From: [Alisa Nicholson](#)
To: [Emily Dickson](#)
Cc: [David M Zabell](#)
Subject: City of Sydney to DPIE - response to SEARs - SSD 10362 - R/2019/10
Date: Friday, 9 August 2019 7:06:49 PM
Attachments: [image002.png](#)
[City of Sydney to DPIE - response to SEARs - SSD-10362 - R-2019-10.pdf](#)
[Documentation - Draft SEARs - SSD 10362 - R201910.DOCX](#)
[Hans Group to DPIE - Request for Delegation - 338 Pitt Street, Sydney - SSD 10362.PDF](#)
[Plan - Inconsistency between approved tower envelope and proposed towers - R 2019 10.PDF](#)

File No: 2019/382263

Our Ref: R/2019/10

Request for SEARs - 330-338 Pitt Street, 241-253 Castlereagh Street and 126-130 Liverpool Street Sydney - New mixed use two-tower development with basement excavation - SSD 10362

- Residential
- Hotel
- Retail
- Plant

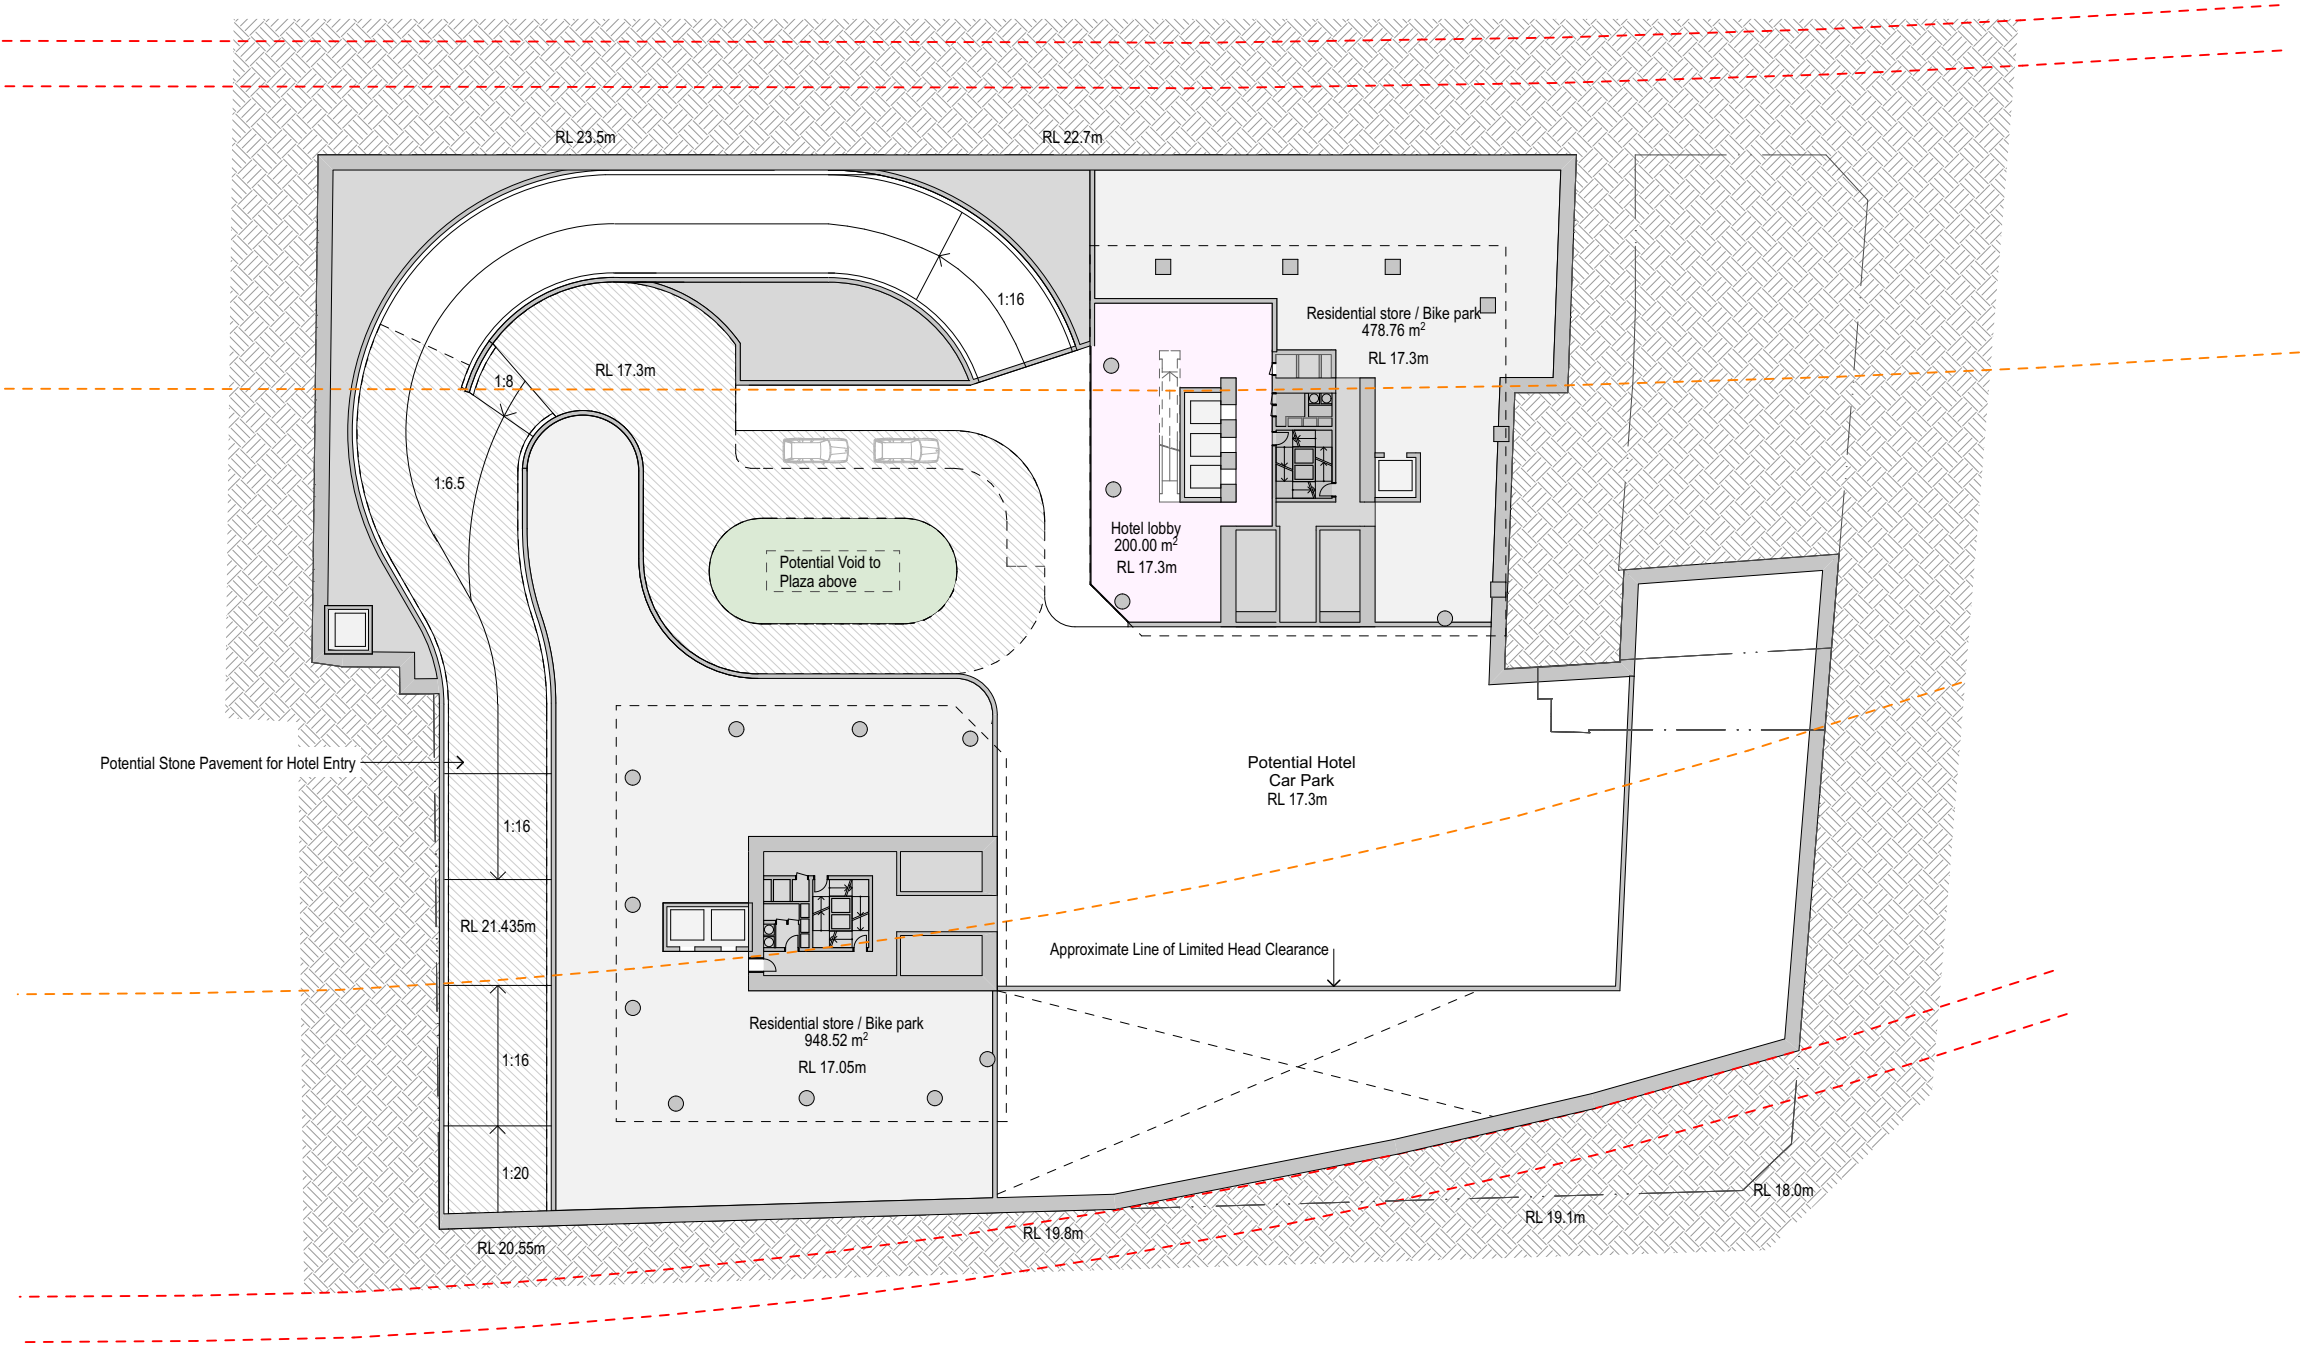
- The proposed towers extend laterally beyond the approved building envelope (see attached).
- Residential floor space is proposed below level 10 contrary to condition 10.
- The towers exceed the lowest maximum height of 276.5 metres on the southwest corner (including the 10% design excellence bonus).

In accordance with Section 4.24(2) of the *Environmental Planning and Assessment Act 1979* ("the Act"), the application must not be inconsistent the concept approval. As such, these matters will be addressed by City staff during the assessment of the application.
